Recommendation Report for Works to Tree(s) on trees subject to a Tree Preservation Order (TPO)

REF NO: FG/5/26/T

LOCATION: 43 Ferringham Lane
Ferring
BN12 5NB

PROPOSAL: Removal of 1no. 'hazard beam' at 6m on west side, 1no. branch at 8m on south side and removal of pinecones, to 1no. Monterey pine (T1)

Photograph 5: showing the branch in question. Defect shown in yellow, pruning cut location to remove branch shown in red; and

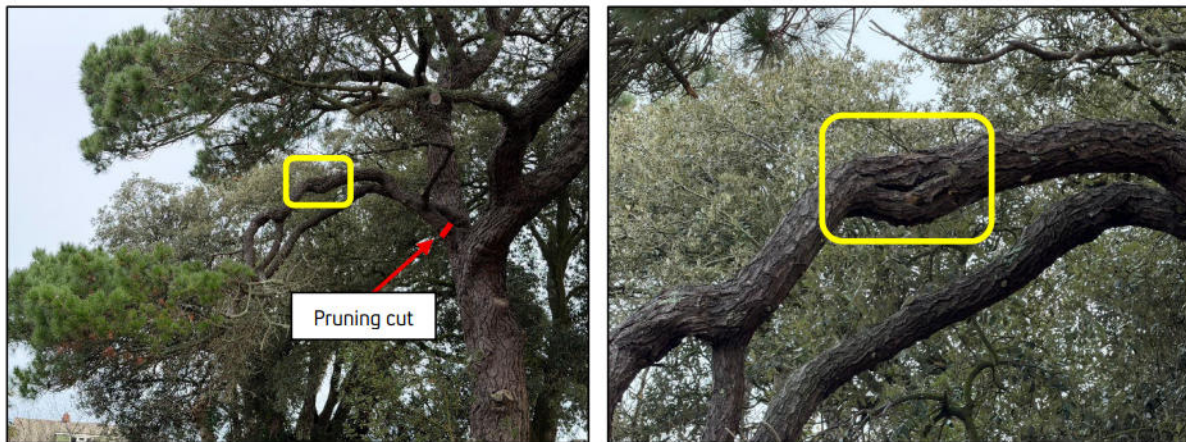
Tree work proposed - Removal of the low split limb ('hazard beam') is necessary and will not incur a loss of amenity. Removal of the mid-height single branch (est.100mm diameter) is similarly uncontroversial and may provide some benefit in terms of risk mitigation without risk of harm to the tree or loss of amenity. The reduction in length of high branches across the crown carries a risk of harm to the tree's long-term vitality and loss of visual appeal.

Recommendations: As it stands, I am unable to support this application. I would like the applicant invited to agree to an alternative proposal for lesser works (as described below) as part of the current application so as not to incur further delay. Such work would go some way to addressing the applicant's concerns whilst ensuring no detriment to tree health or loss of amenity: "Removal of 1no. 'hazard beam' at 6m on west side, 1no. branch at 8m on south side and removal of pinecones, to 1no. Monterey pine (T1)."

Photograph 7: showing pruning requirements to reduce the likelihood of cone fall causing further damage or injury to 43 Ferringham Lane.

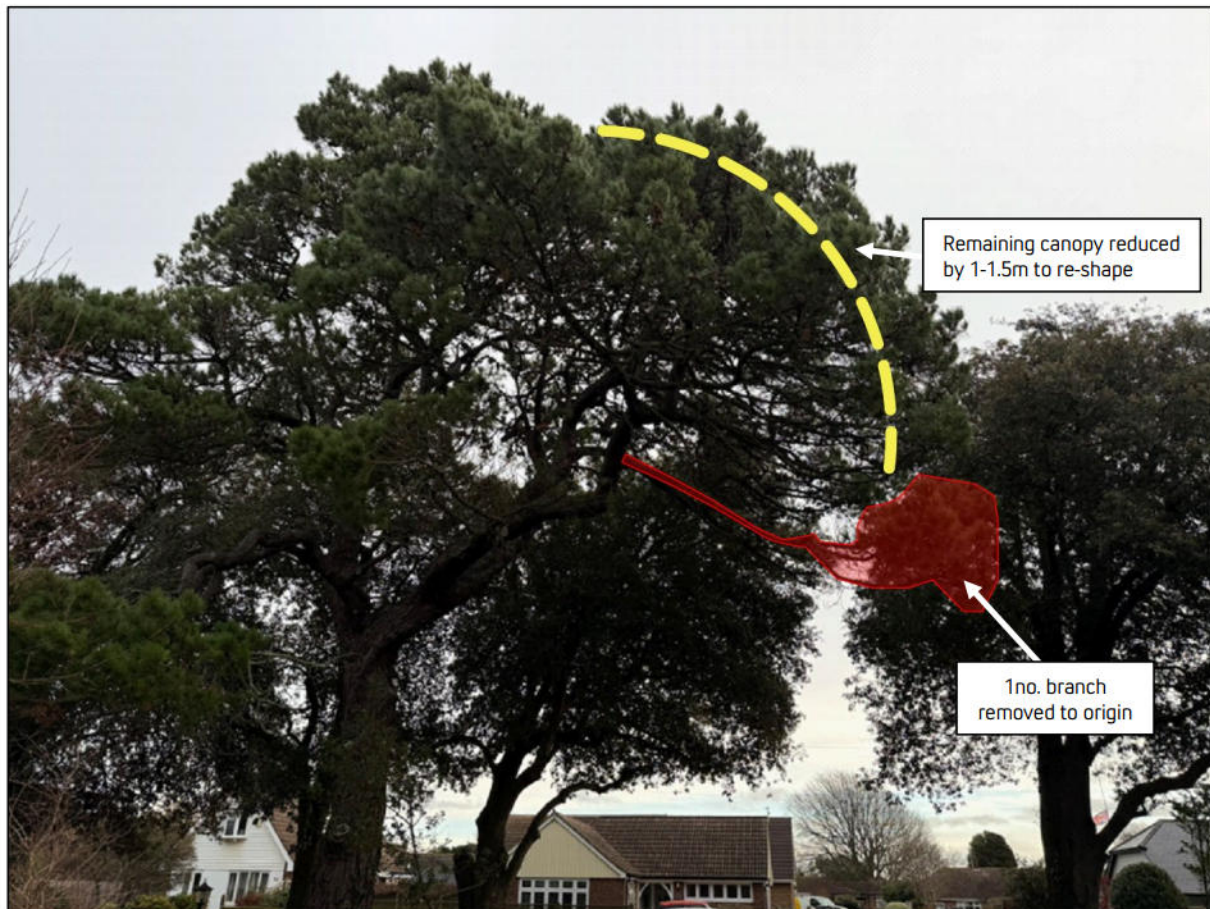
The tree is a significant feature in the local landscape and appears to be in adequately sound and healthy condition. A majority of the tree surgery proposed in the application would likely result in undue harm to vitality and undue detriment to the visual amenities of the locality.

The risks presented by this tree can be managed to a reasonable level by regular inspection, pinecone removal as an alternative to upper crown branch reduction pruning and a precautionary approach to use of land beneath the canopy.
